Your ref: 3/2018/0147FUL and 0149/LB

Date: 23rd March 2018

Planning Applications 3/2018/0147/FUL and 0149/LB: Proposed change of use from office (B1) to residential (C3) including minor internal alterations to form separate dwelling, ground floor apartment and duplex apartment. Proposed installation of electronically operated black wrought iron gates to the existing vehicular entrance and the existing boundary opening to the north east site boundary. Stanley House, Lowergate, Clitheroe BB7 1AD

BASEMENT

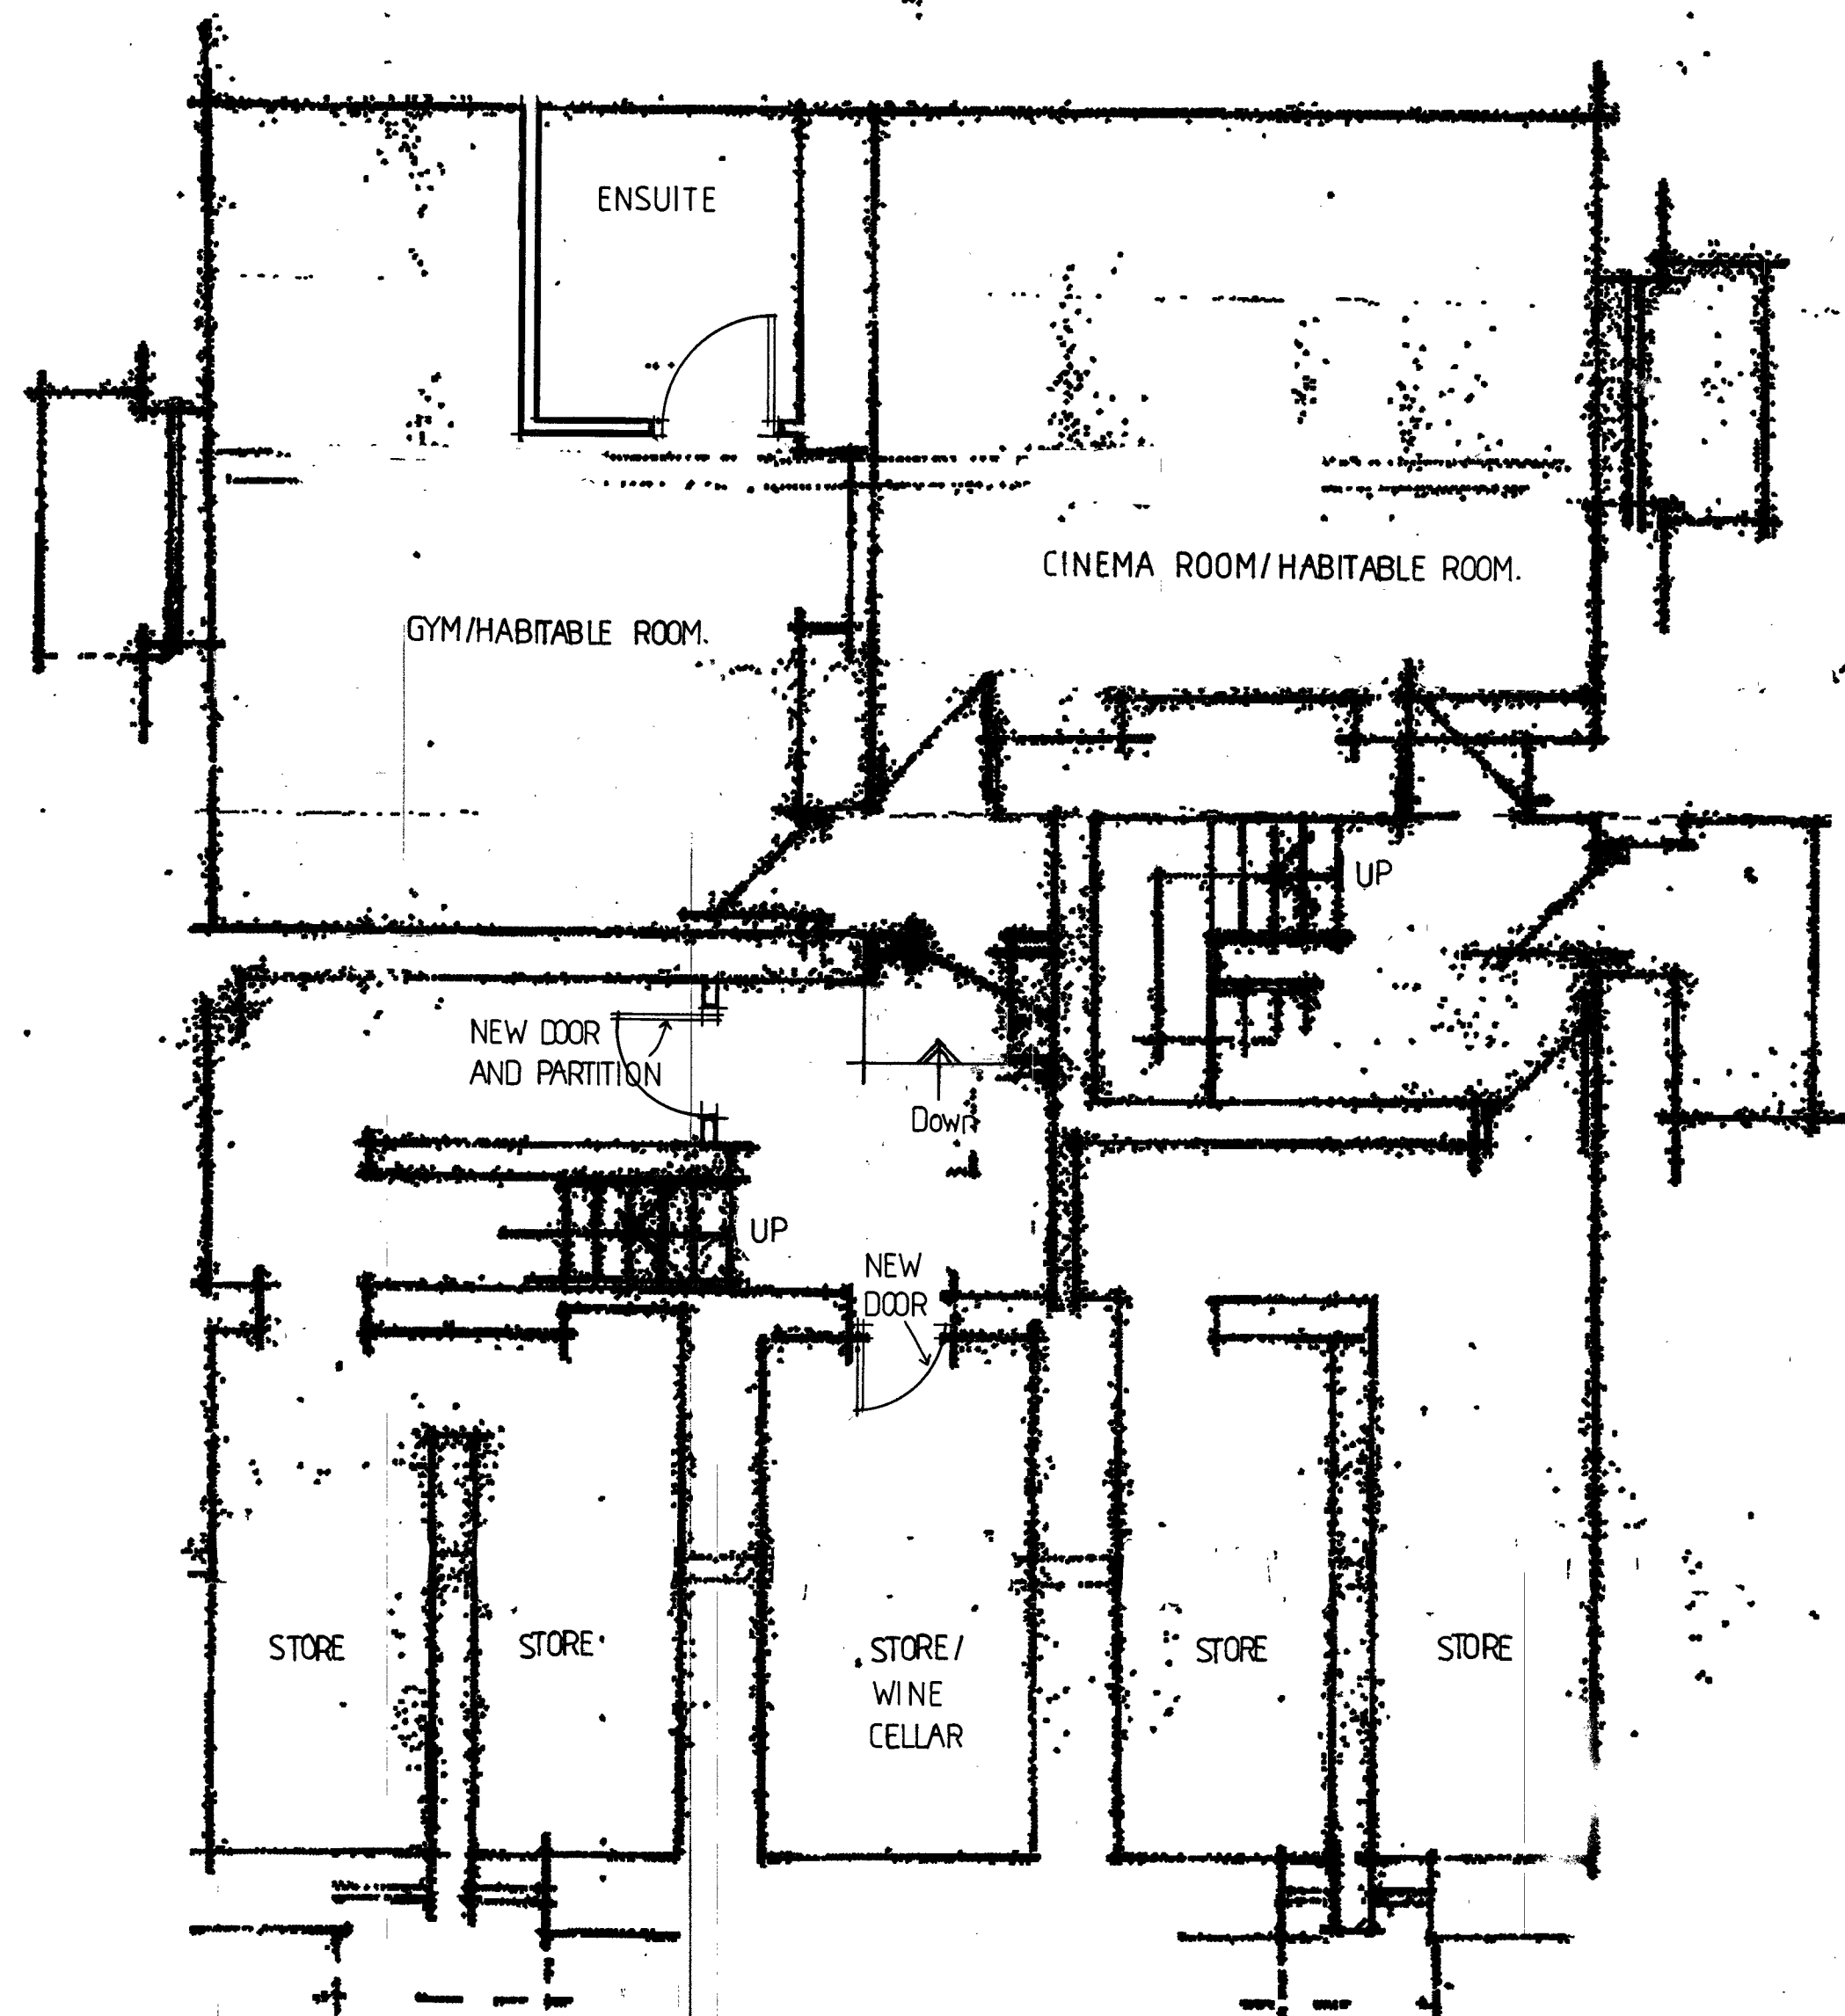
It is also not clear what works are proposed to the basement and utility room, with regard to the '*water-proofing*', although the installation of a '*sump chamber and evacuation pump*' are required (HS 7.2.1) which is likely to require disturbance to the floor. Given concerns over the quality of '*damp surveys*' and potential impact of '*damp-proofing*' in historic buildings, we would advise that the full details of the damp issues in the basement and utility room and what works are proposed are submitted and that these are closely checked by your Conservation Officer and/or an independent and qualified expert with experience in historic buildings. Dealing with water ingress from failed gutters, flashing, etc. and removing the excessive climbing vegetation to the utility room area should be investigated before any intrusive and/or chemical damp proofing is considered. It is also worth considering if the removal of the cement render from the building (and replacement with lime-based render if required) would be appropriate.

No details are supplied regarding the installation of a new 'ensuite' in the basement (HS 7.6.8), particularly with regard to service runs or other intrusive works.

We would agree, however, that a programme of building recording is a sensible and prudent step (HS note, p.26) and would recommend that, given the reported survival of 17th century elements (HS 6.1), that this should be to Level 3, as set out in "*Understanding Historic Buildings*" (Historic England, 2016). This can be required by condition, the following wording is suggested:

Condition: No development shall take place until the applicant, or their agent or successors in title, has secured the implementation of a programme of archaeological recording works. This must be carried out in accordance with a written scheme of investigation, which shall first have been submitted to and agreed in writing by the Local Planning Authority. The programme of works should include the creation of a record of the building to Level 3 as set out in '*Understanding Historic Buildings*' (Historic England 2016). It should include a full description of the building inside and out, a drawn plan, elevations and at least one section (which may be derived from checked and corrected architect's drawings), and a full photographic coverage, inside and out. The record should also include a rapid desk-based assessment, putting the building and its features into context. This work shall be carried out by an appropriately qualified and experienced professional historic building survey contractor to the standards and guidance of the Chartered Institute for Archaeologists (CIfA).
